From: Gilbert LaForce
Sent: Tuesday, November 29, 2022 3:01 PM
To: Corey Petersen (corey.petersen@matrixdesigngroup.com)
Cc: Brad Walters; 'herebic5@msn.com'; Justin Kilgore
Subject: RE: SF2026 Grandwood Ranch Record Drawings

From: Corey Petersen <Corey.Petersen@matrixdesigngroup.com>
Sent: Wednesday, November 23, 2022 11:14 AM
To: Gilbert LaForce <GilbertLaForce@elpasoco.com>; Brad Walters <BradWalters@elpasoco.com>
Cc: Bill&Ashley Herebic <HEREBIC5@msn.com>
Subject: Grandwood Ranch Record Drawings

GRANDWOOD RANCH	
EL PASO COUNTY - SF 2026 ROAD AND STORM PLANS	
ROADWAY GENERAL NOTES	
DESIGNED BY: CAP DRAWN BY: NMS CHECKED BY: NMS	SCALE: HORIZ. N/A VERT. N/A DATE ISSUED: FEBRUARY, 2021 SHEET 4 OF 40 DRAWING No. TY01

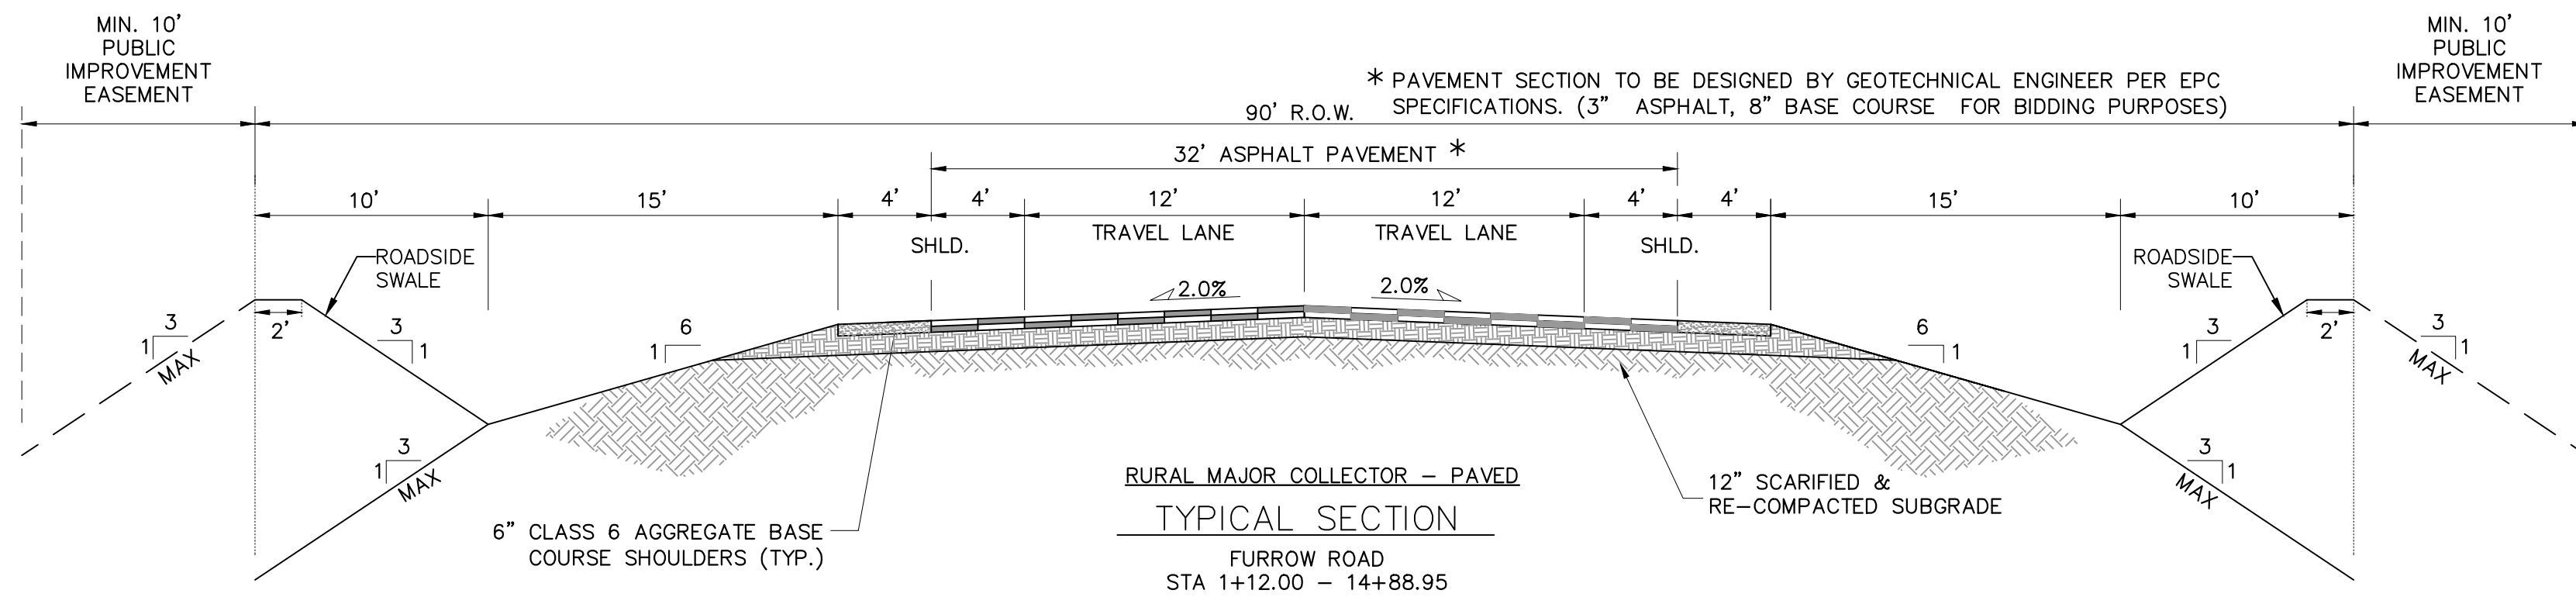
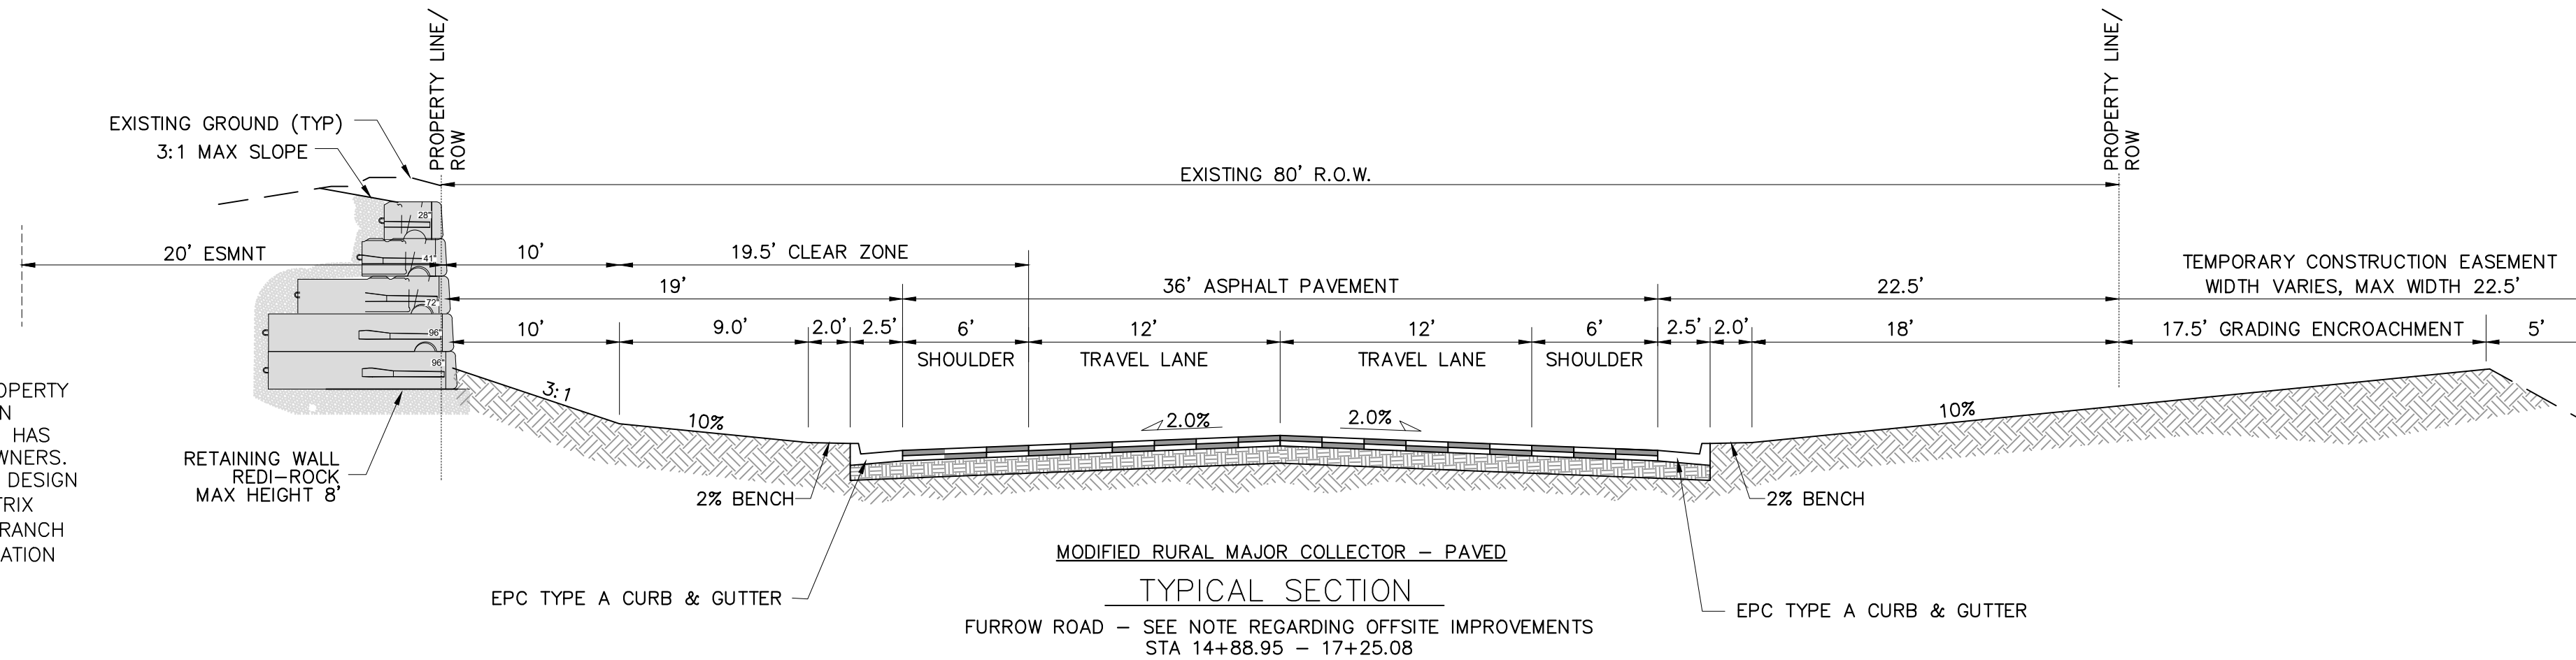
1. Add a note on sheet 4 (TY01) that the offsite cross section to be completed in the future and not included with this record drawing set similar to the note placed on sheet 8 (RD03).
2. Update sheet 4, 9, 10, 11 to reflect not constructing the cross pans.
3. Update sheet 39 & 40 (striping plan) based on the asbuilt notes on sheet 5.
4. The bollards on site does not include the 3 bands of tape per sheet 12, is this being installed?
5. I was informed the Emergency Access Gate has not been installed.
6. On sheet 15 the access geometry does not appear to reflect what was constructed.
7. Per ECM 5.10.6.B submit a certification letter for the asbuilt and for the detention facility. The certification letter shall provide the specific statement described in the referenced section. The certification letter shall include the MHFD design worksheet reflecting the as-built pond.
